Pear tree Hill Solar Farm

Change Application (September 2025)

Document Ref: EN010157/APP/8.9

September 2025

### Figure 14.2: Transport Routing and the Existing Highway Network

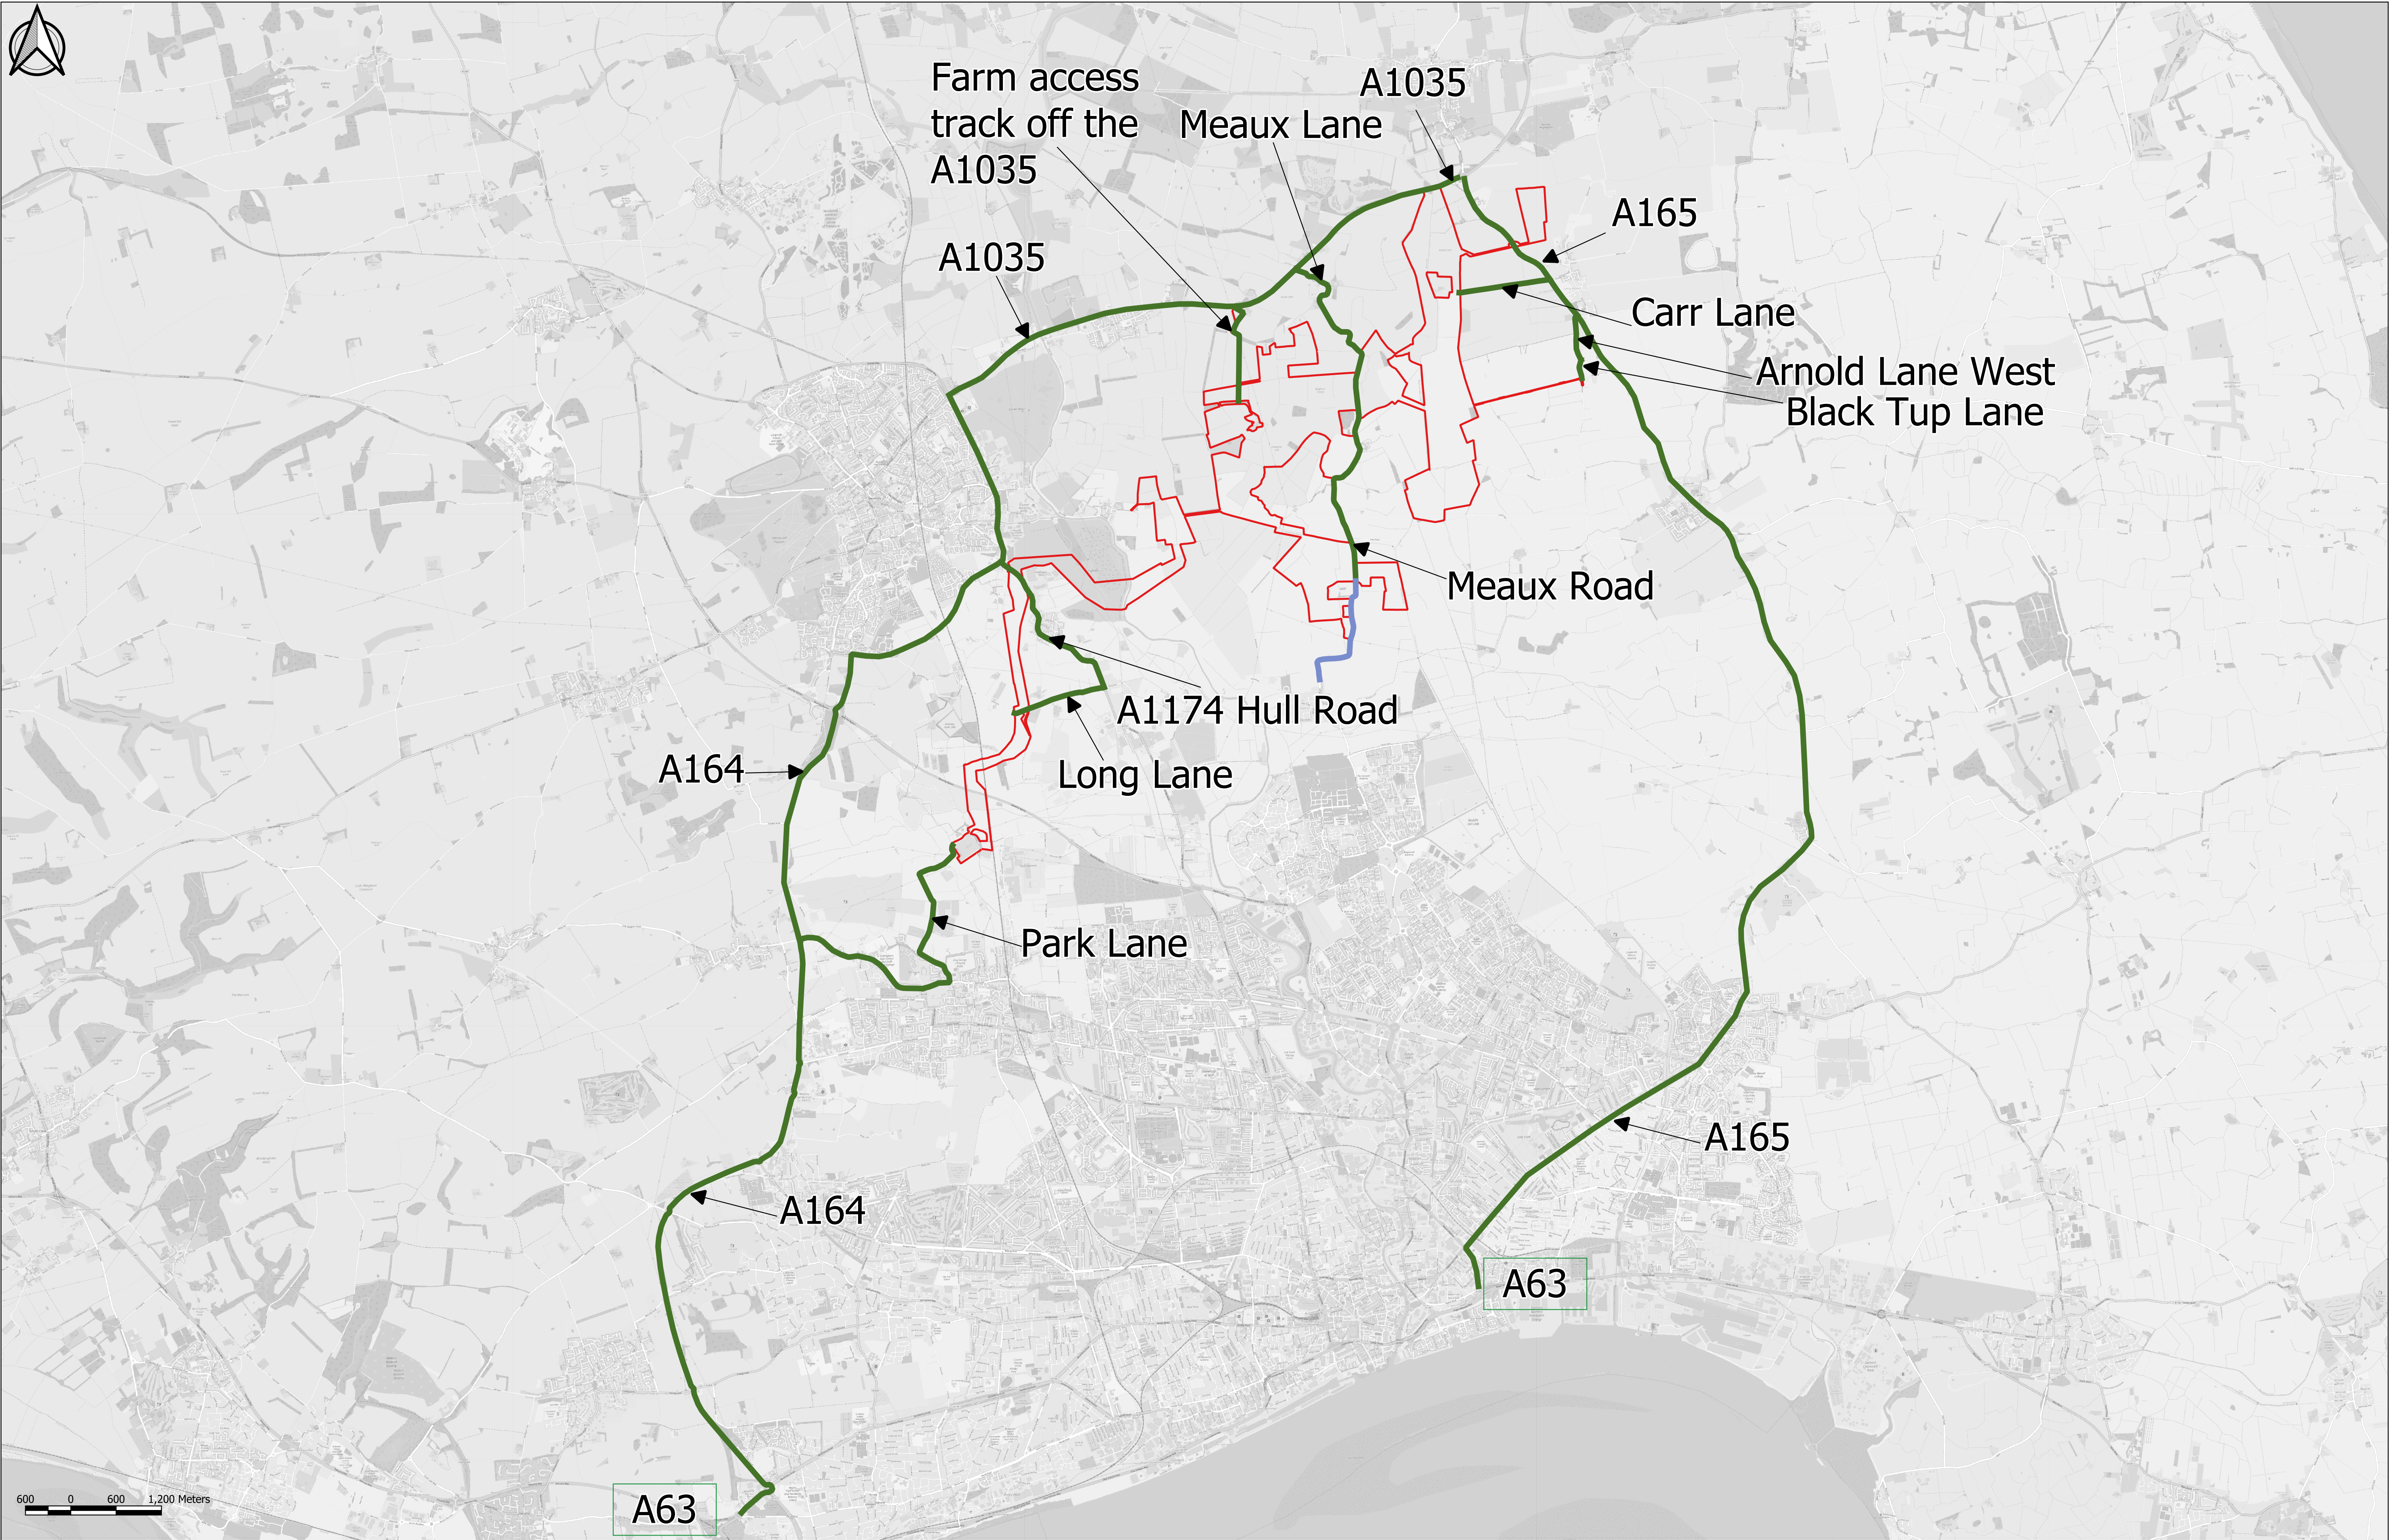
Transport and access	No new construction traffic would be generated by Change 3. Due to the low number of vehicle movements that would use the new access off the A165 over a short period of time for the construction of Cable B-B interconnecting cable route, effects of Change 3 would not be significant. The relevant transport link ('A165 White Cross Road, between White Cross Roundabout and Carr Lane (Long Riston)'), which	No materially new or different effects have been reported in the ES as a result of Change 3.

encompasses the Change 3 location, is assessed in ES Volume 2, Chapter 14: Transport and Access [EN010157/APP/6.2 Revision 3] with effects concluded to be not significant following the implementation of measures in the Outline CTMP [EN010157/APP/7.7 Revision 3] . As set out in the Traffic Measures Plan [EN010157/APP/2.9 Revision 3] and Schedule 7, Part 1 of the Draft DCO [EN010157/APP/3.1 Revision 6] , traffic measures would be employed at this location to ensure the safety of road users.	
Cumulative effects	No potential new environmental effects are likely to occur as a result of this change in comparison with the assessment work already undertaken within the ES.	No materially new or different effects have been reported in the ES as a result of Change 3.

EN010157/APP/6.2	6.2 ES Volume 2, Chapter 14: Transport and Access	3	Update to include reference to new access point.
EN010157/APP/6.3	6.3 ES Volume 3 (all figures with the exception of Figure 4.1 and Figure 4.2 as these show previous versions of the Order Limits)	-	Update all ES Figures to show change to the Order Limits.
EN010157/APP/6.3	6.3 ES Volume 3, Figure 3.4: Indicative Environmental Masterplan	2	Update to show retained/ impacted vegetation.
EN010157/APP/6.3	6.3 ES Volume 3, Figure 6.2: Trackout Activities Study Areas	3	Update to show new locations for trackout activities.
EN010157/APP/6.3	6.3 ES Volume 3, Figure 14.2: Transport Routing and the Existing Highway Network	4	Update to show new construction route.
EN010157/APP/6.4	6.4 ES Volume 4, Appendix 7.10: Biodiversity Net Gain Assessment	3	Update to account for minor changes to hedgerow and area units.
EN010157/APP/6.4	6.4 ES Volume 4, Appendix 7.11: Arboricultural Impact Assessment	3	Update to account for hedgerow/ tree impacts in relation to Change 3.

Figure 1.2: Land Areas and Cable Routes Plan with Field Numbering System

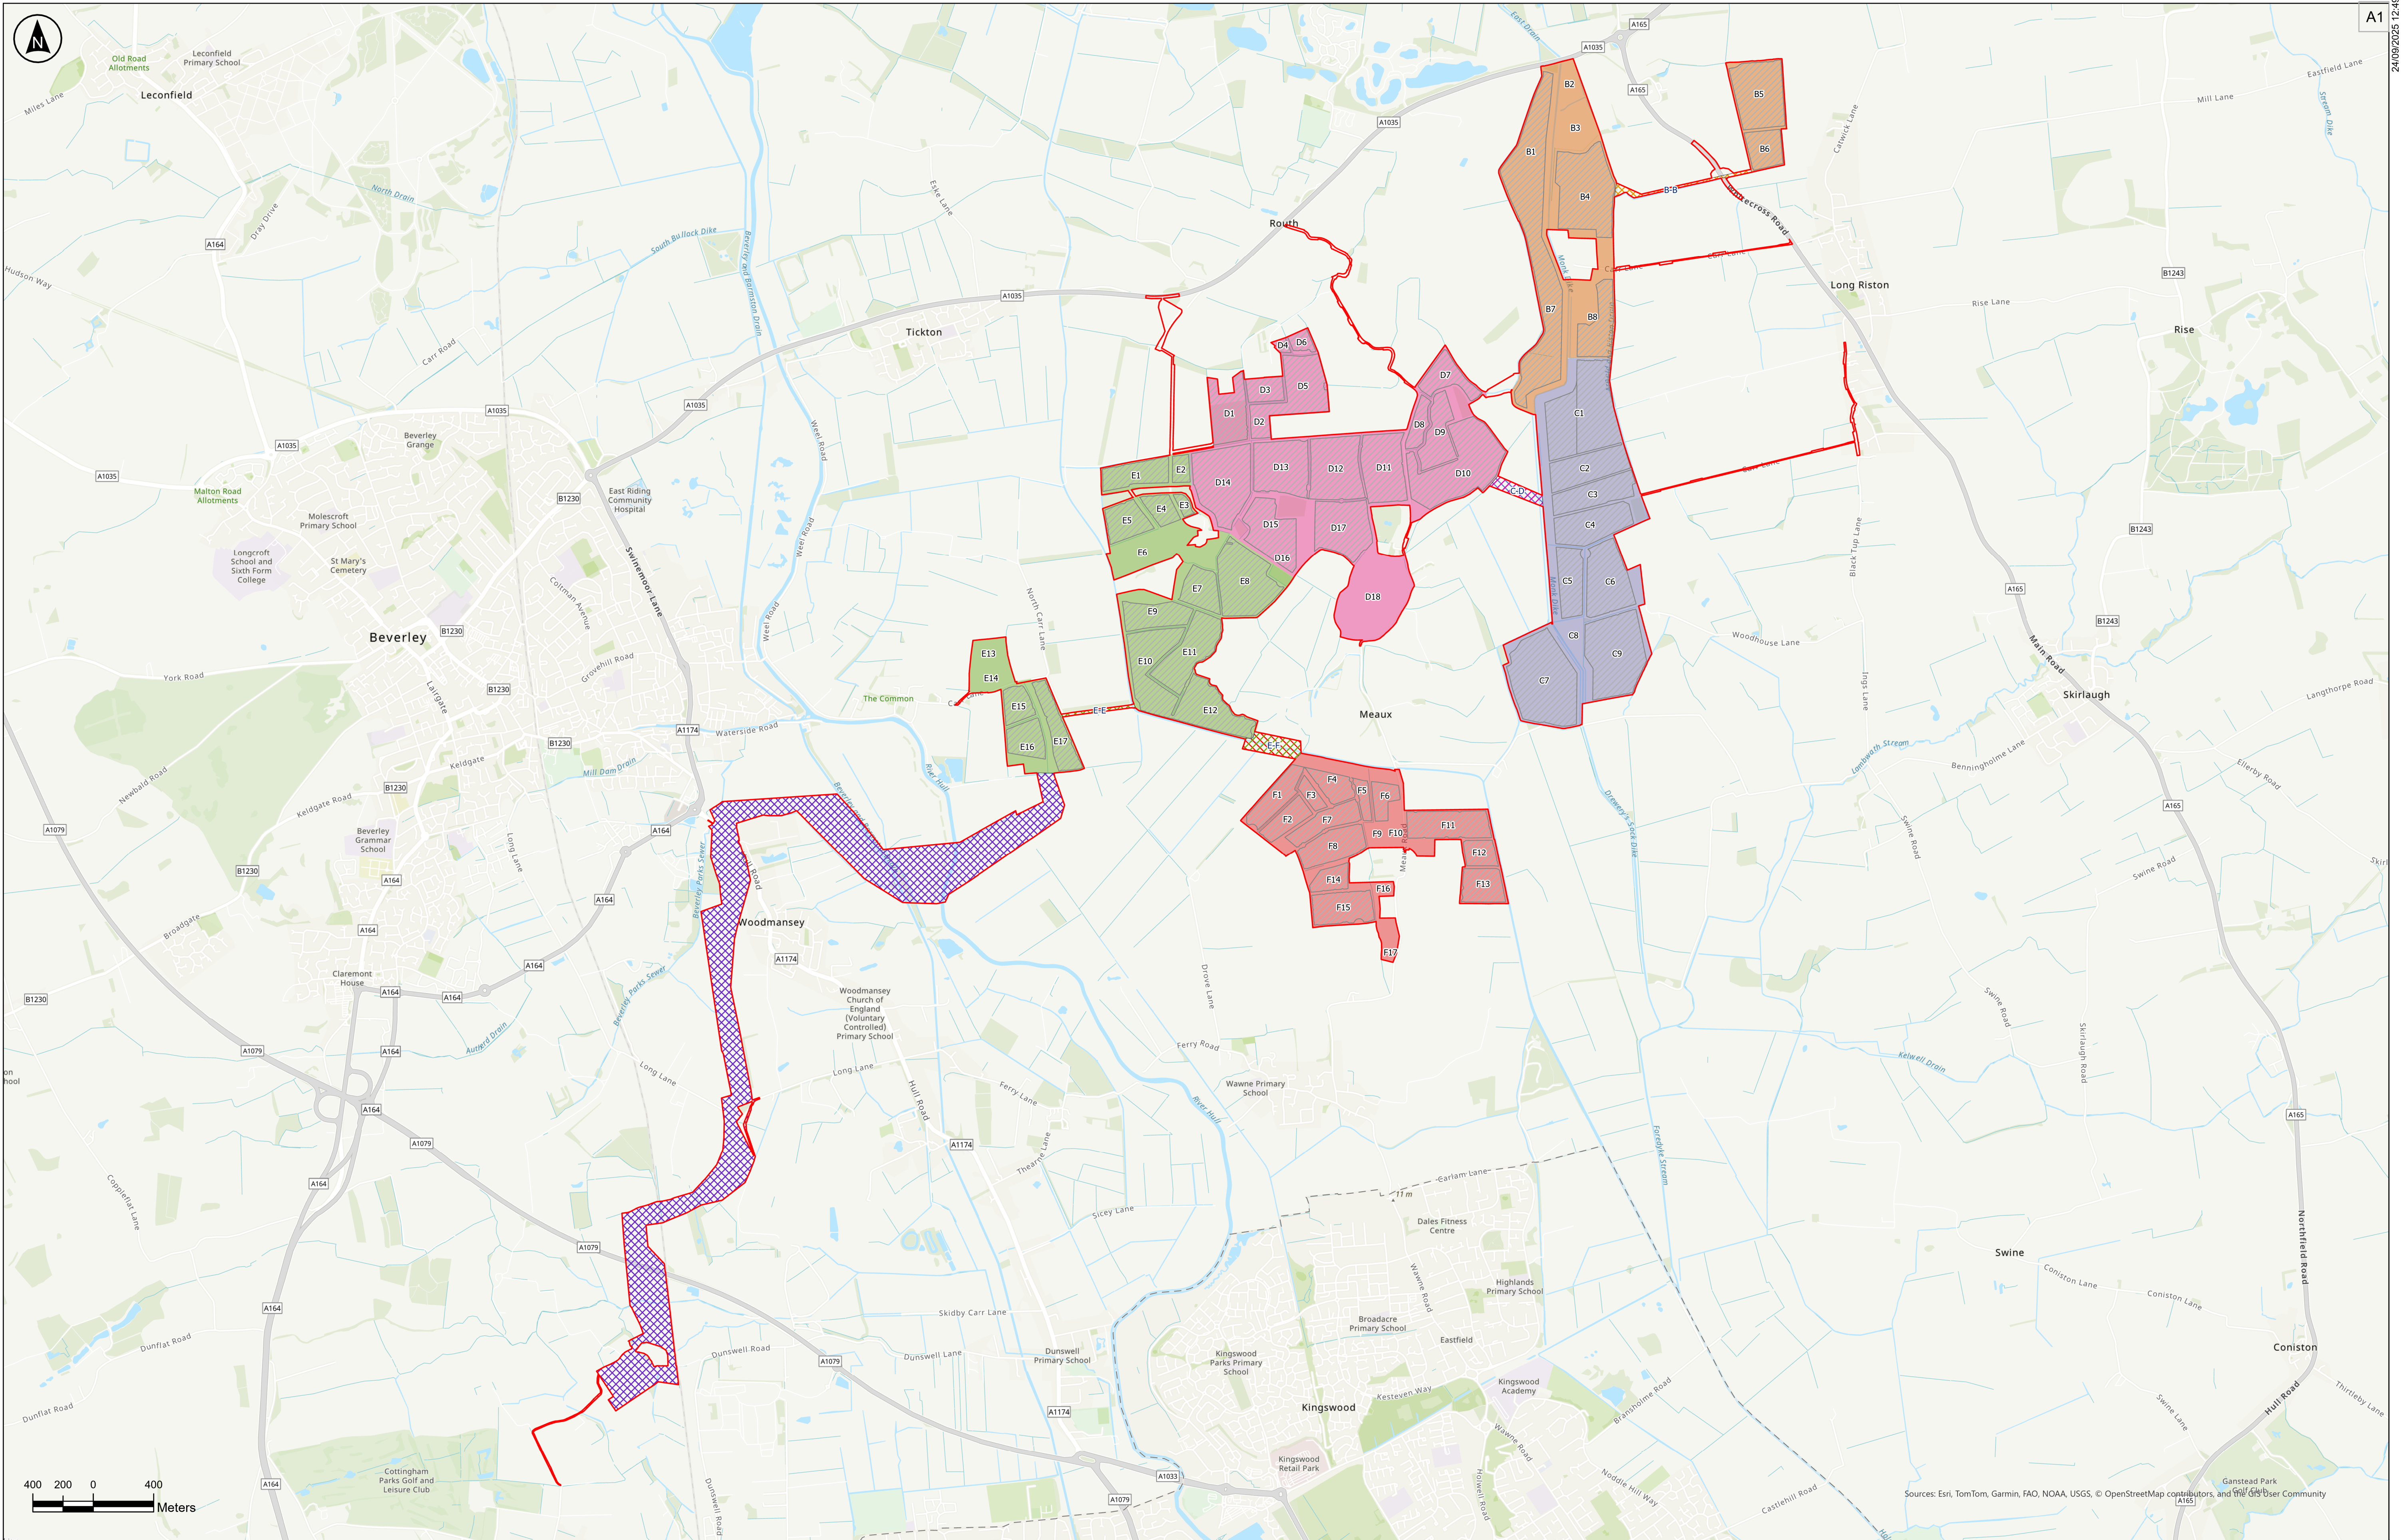
- 7.1.1 The Applicant has reviewed the proposed vehicular access between Fields C5 and C8. In the DCO Application as submitted, this was proposed to be taken via the existing crossing of Arnold and Riston Drain linking Field C5 with Field C8 (see sheet 8 of 17 of **ES Volume 3, Figure 3.4: Indicative Environmental Masterplan [APP-058]**). The crossing would then enable access to be taken to the southern fields in Land Area C, namely Fields C6, C7, C8 and C9.
- 7.1.2 However, following a further review of the existing crossing, the Applicant does not consider that the crossing is suitable to accommodate construction vehicles. This is due to the tight angle of the crossing and lack of clearance for vehicle swept paths.

- 7.2.1 A new crossing of Arnold and Riston Drain is proposed, linking the south-eastern corner of Field C5 with the north-eastern corner of Field C8. Building a new crossing would be preferable to reinforcing the existing crossing due to the turning angle needed by the construction vehicles and existing complexities in bridge layouts in terms of proximity and incline. The bridge would be constructed to a standard appropriate for use by construction vehicles and would be left in situ for the lifetime of the Proposed Development to enable access to be taken to Fields C6, C7, C8 and C9 for maintenance. Plans of the crossing would need to be submitted in advance for the approval of Beverley and North Holderness Internal Drainage Board in accordance with the protective provisions for drainage authorities in Part 3 of Schedule 12 to the **Draft DCO [EN010157/APP/3.1 Revision 6]**.

- 7.2.2 The proposed new crossing location would also enable some simplifications to be made to the access tracks in this location. In particular, rather than laying two access tracks either side of Arnold and Riston Drain, a single track to the south of Arnold and Riston Drain would be sufficient.
